Appendix B

Response to Submissions

**Figure 1 | Proposed Heavy Vehicle and OSOM Transport Route**

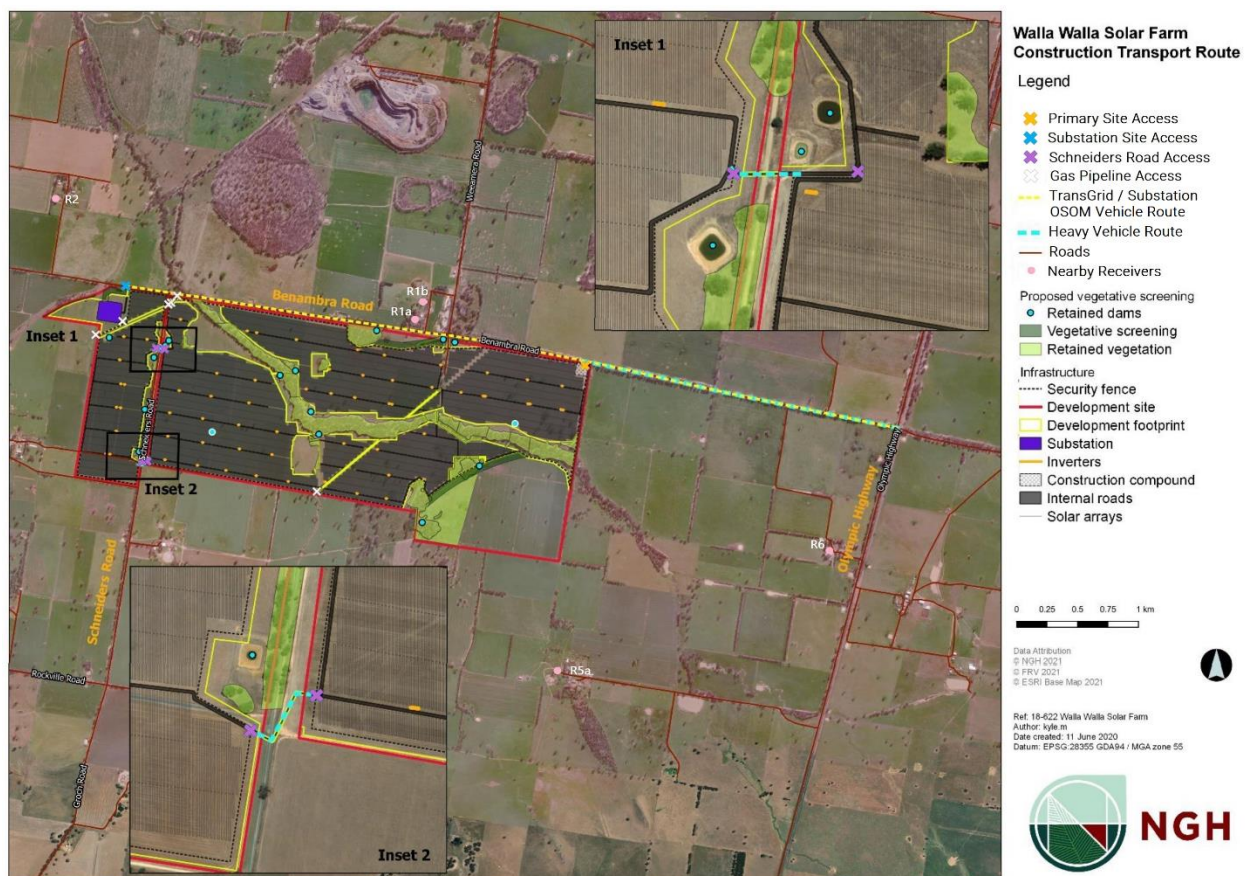
Greater Hume Council	<ul style="list-style-type: none"> There does not appear to be sufficient cause for continuing the use of the unsealed section of Benambra Road and all traffic should run through the site. This would cut down on compliance issues because nearby residents have raised concerns about the use of Benambra Road. 	Following discussion with Transgrid and Greater Hume Shire Council, and in response to community concern, FRV has committed to discontinuing use of the Substation Access for Heavy Vehicle use during the construction period.
DPE Water	<ul style="list-style-type: none"> The proponent should confirm there have been no modifications to the approved setbacks required for all watercourses on site. Works within waterfront land need to be in accordance with the Guidelines for Controlled Activities on Waterfront Land 	<p>FRV can confirm that the modification does not propose to change the approved setbacks from Back or Middle Creek. FRV will maintain a 30 m setback from Back Creek, and a 20 m setback from Middle Creek.</p> <p>FRV will ensure that the crossing over Back Creek is constructed in accordance with the Guidelines for Controlled Activities on Waterfront Land, as is currently required by condition 28(d) of Schedule 3 of the consent.</p>

All heavy vehicle traffic should use the internal road, restricting use of unsealed section of Benambra Road	S-42952553 S-42952379 S-42947062 S-42930395	<ul style="list-style-type: none"> Following feedback from the community, and after discussions with Transgrid, FRV can commit to relinquishing heavy vehicle access during construction to the Substation Access point. This means that all heavy vehicles would now enter the site via the Primary Site Access point, and travel within the site to reach the substation area. Over-dimensional vehicles transporting substation components would still need to reach the substation via Benambra Road, as the internal road would not be suitable for these vehicles. The substation access may also still be used by light vehicles and vehicles during the project's operational stage. FRV would include Benambra Road, between Weeamera Road and the Substation Access point, in its pre and post construction dilapidation surveys, and repair any damage in accordance with the conditions of consent. 	Proposed update to condition 6 of Schedule 3, to remove consent for up to 10 heavy vehicles to use the substation access point.
